Application for a non-material amendment following a grant of planning permission.

Number	
Suffix	
Property name	Elderberry House
Address line 1	Nyton Road
Address line 2	
Address line 3	
Town/city	Westergate
Postcode	PO20 3UQ
Description of site location must be completed if postcode is not known:	
Easting (x)	493894
Northing (y)	105664
Description

Part two storey part single storey rear extension, single storey side extension and two storey front extension.

Reference number:	AL/32/20/HH
Date of decision	10/06/2020

DRAWING TITLE
Proposed plans and elevations

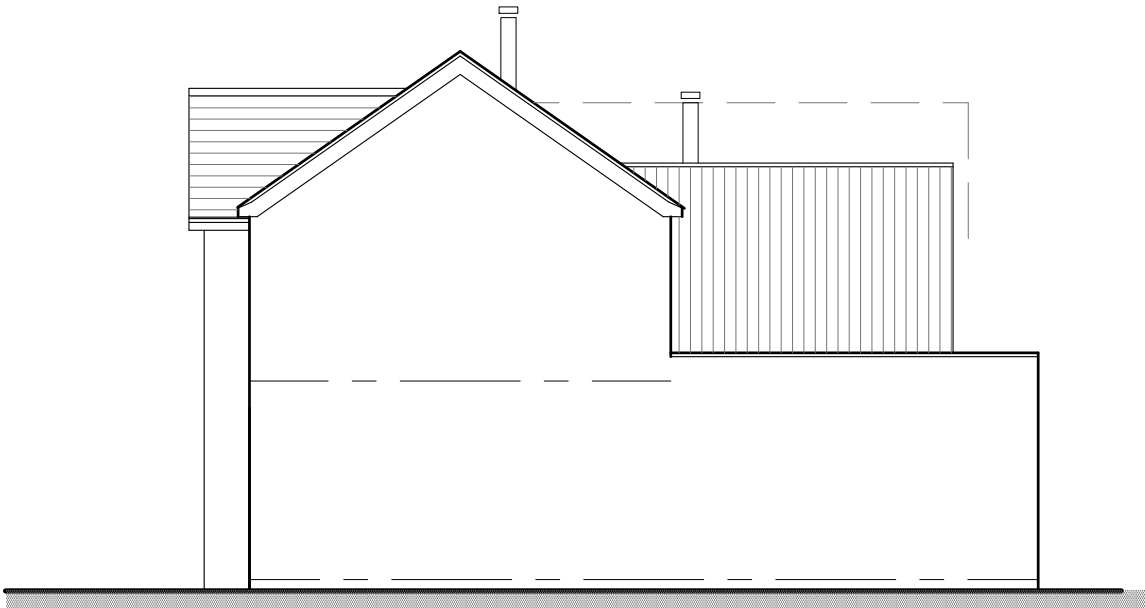
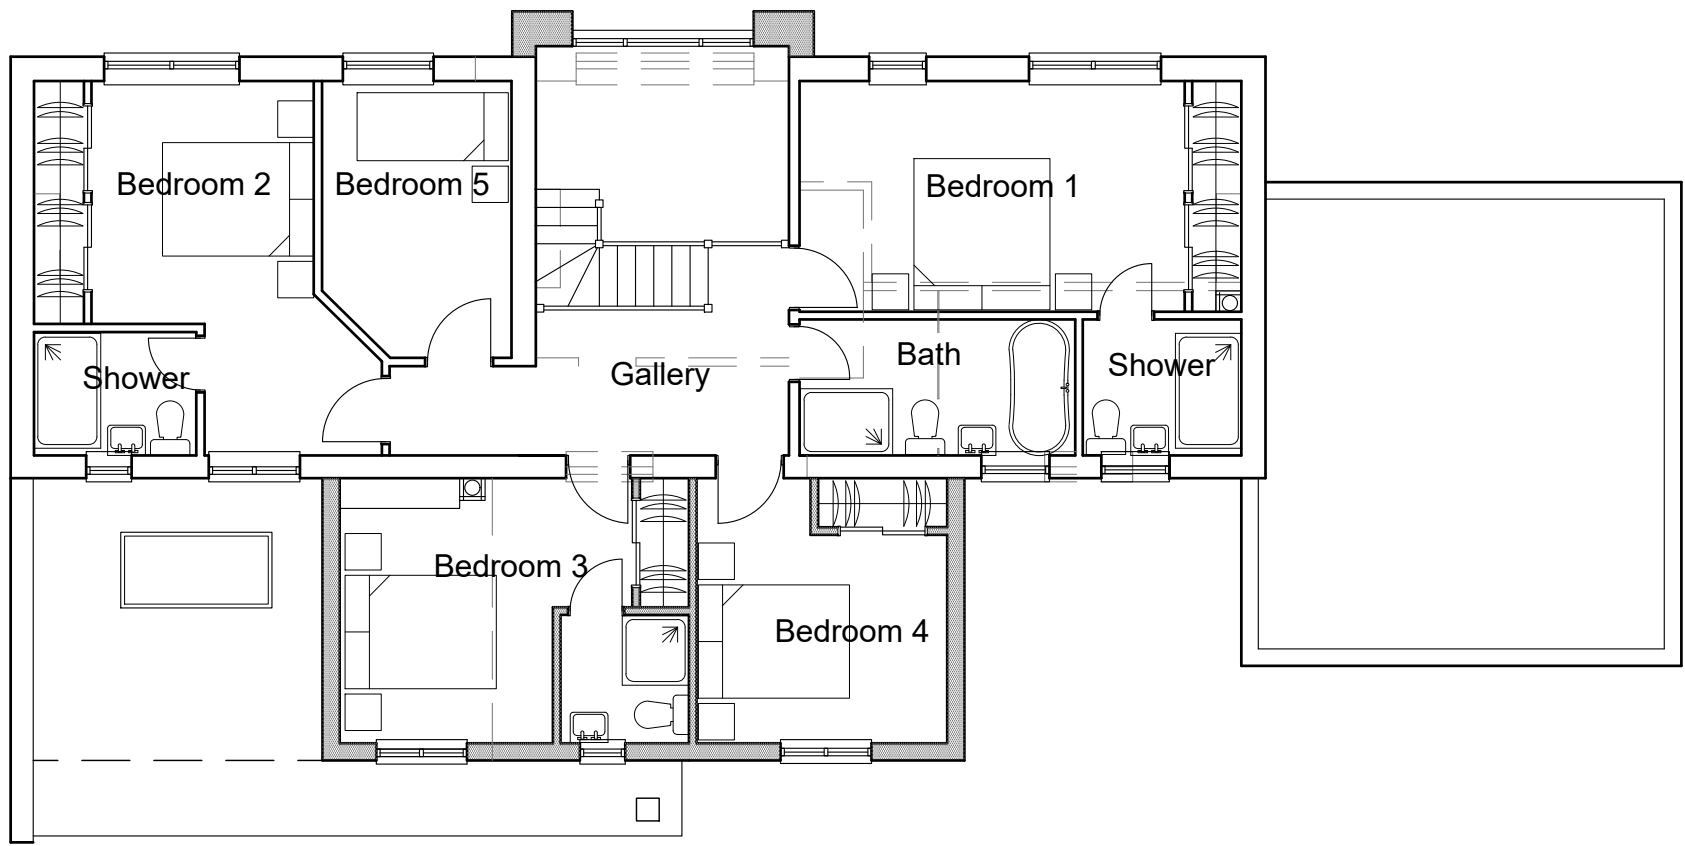
Changing the proposed cladding from fibre cement boarding to Cedar boarding

20-05-2.01 Revision C

20-05-2.01 Revision D
